DATE	27/04/2022	JOB	2808	PAGES	1 of 2
PROJECT	SSD-10371 - Trinity Grammar School The Renewal Project SSD				
TO	Peter Brogan				
COMPANY	Bloompark Pact				
FROM	PMDL				
REFERENCE	Architectural Modifications - Response to RFI

Architectural Modifications - Response to RFI

The letter is in response to the Architectural RFI items identified on the Department of Planning and Environment's RFI letter on 8th April 2022.

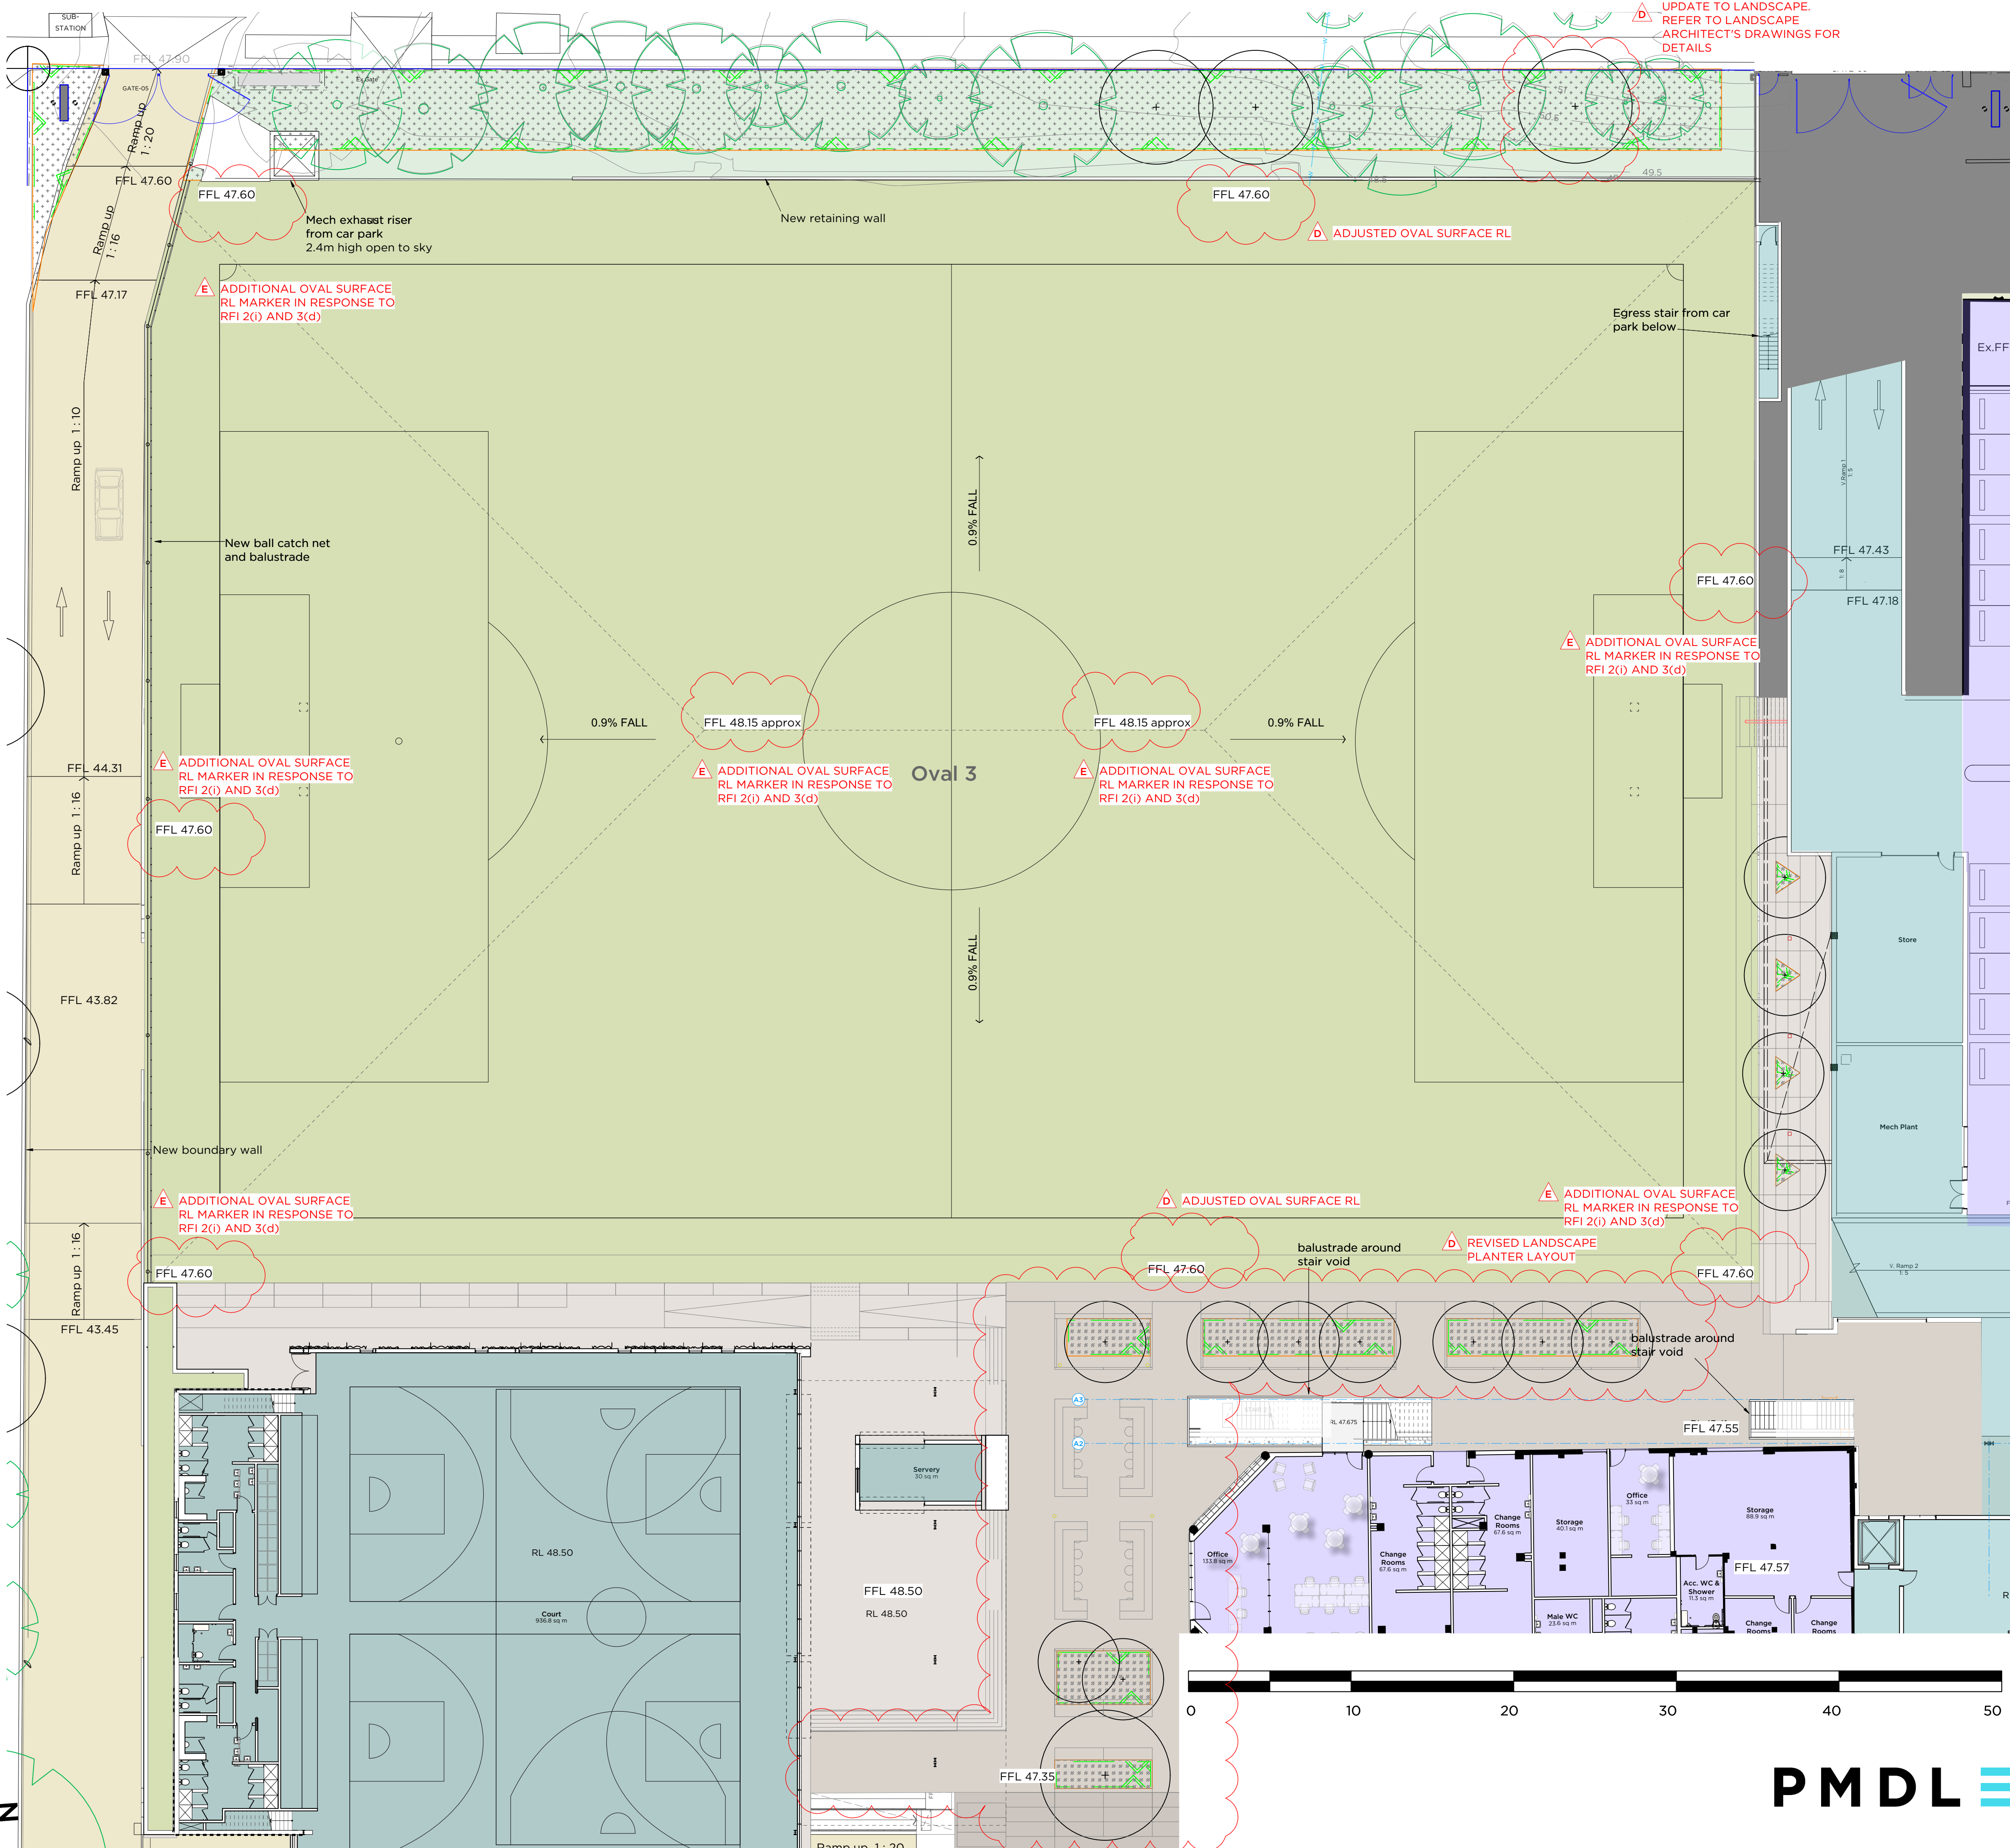
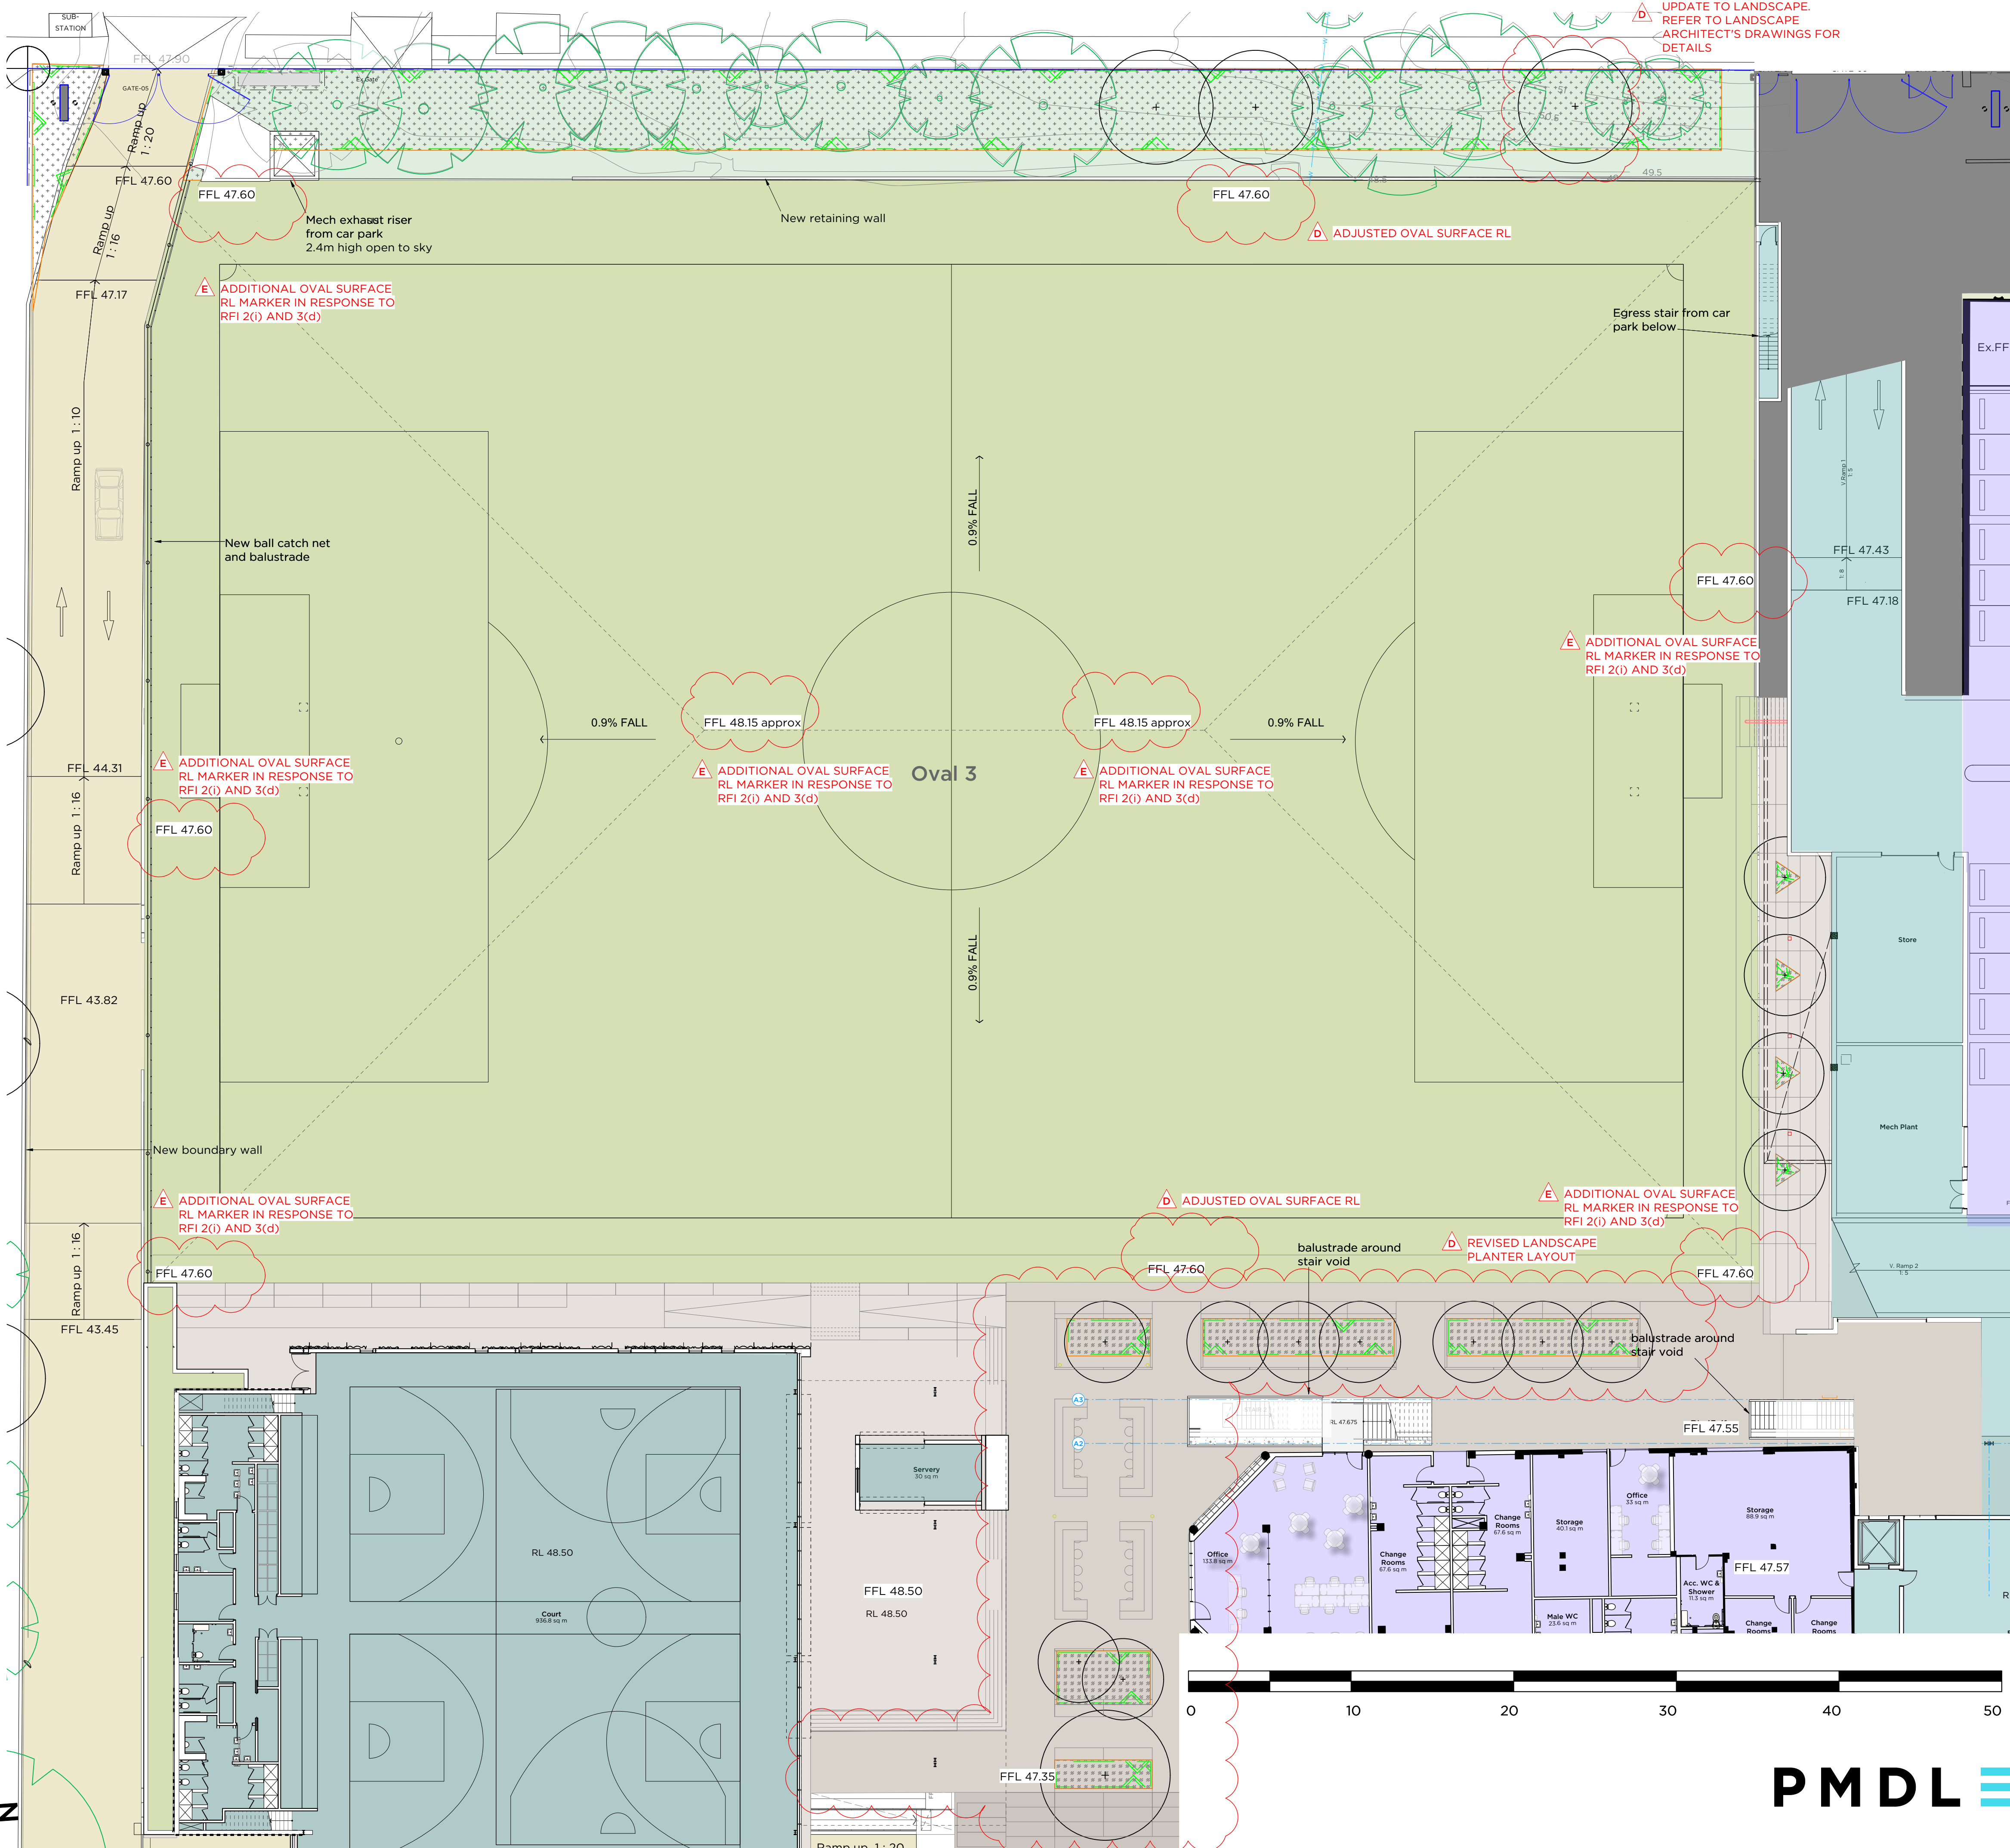
3(d) The Oval 3 plan (2808 DA151 Revision D) has included annotations of "fall" from the centre of the oval. Further spot levels are required to be detailed for the Department to assess this aspect of the proposal.

The updated drawing **2808 DA151 Proposed Oval 3 Car Park B1 E** shows additional surface RLs along the perimeter edge of Oval 3 at FFL 47.60 as per the modification proposal. The fall of the oval has now been updated and the proposed level, FFL 48.15 approx, at the centre of the Oval is shown.
